CONSULTEE RESPONSE (Council's Arboriculturist)

Reference: AW/164/26/T

Proposal: Crown lift to 1 no. Broad Leaf Lime (T1) to a height of 2.5m from ground level on the East side and 5m from ground level on the West side, crown reduction to leave an Easterly spread of 3m.

Location: Redstacks, The Byeway, Aldwick Bay Estate Bognor Regis PO21 4ES

View from the resident's garden.

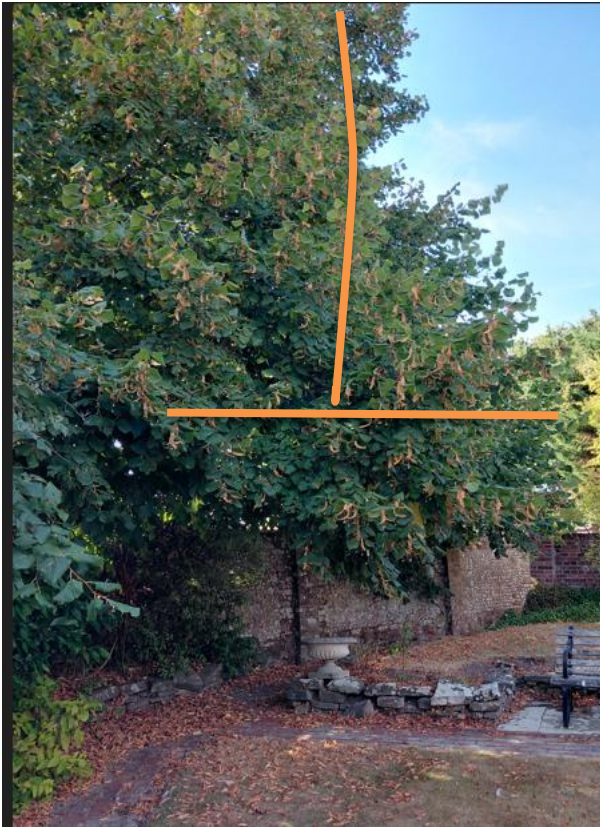
The proposed crown lift to 2.5m on the East side is also considered acceptable and should provide sufficient clearance beneath the canopy.

The proposed reduction to leave an easterly spread of 3m is proportionate to the identified management requirements and can be achieved whilst retaining the tree's natural form, health, and amenity value.

We grant consent for the proposed works (T1) subject to the following condition:

Part a) Where whole branches are to be removed and final cuts made close to the trunk or branch union they are to be made as shown in Figure 2 of BS3998:2010

Part b) Where branches are to be shortened back the final cuts are to be made at the correct angle shown in BS3998:2010 and adjacent to a live bud or lateral.

View from The Byeway roadside.

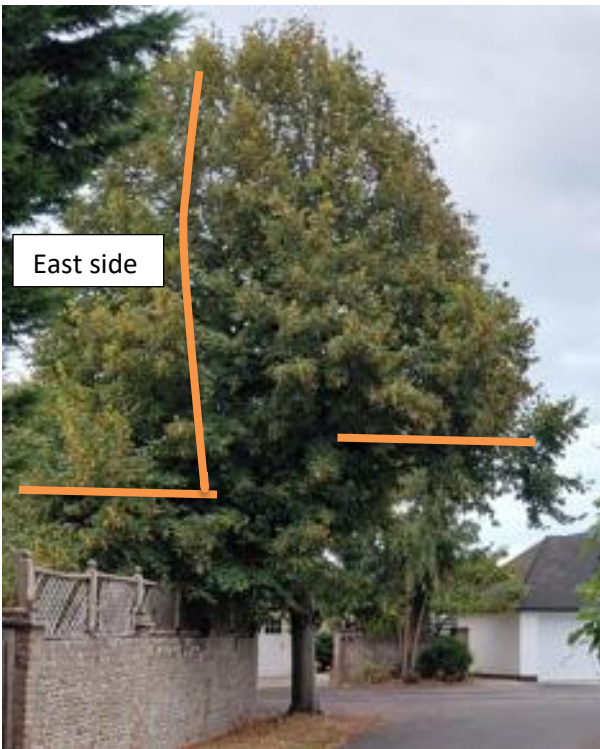
From a roadside view it appears to be in good physiological and structural condition. It has previously been the subject of a West side reduction. In view of the tree's contribution to local amenity the roadside crown should not be reduced further than that necessary to maintain the existing 5m clearance in accordance with highway requirements.
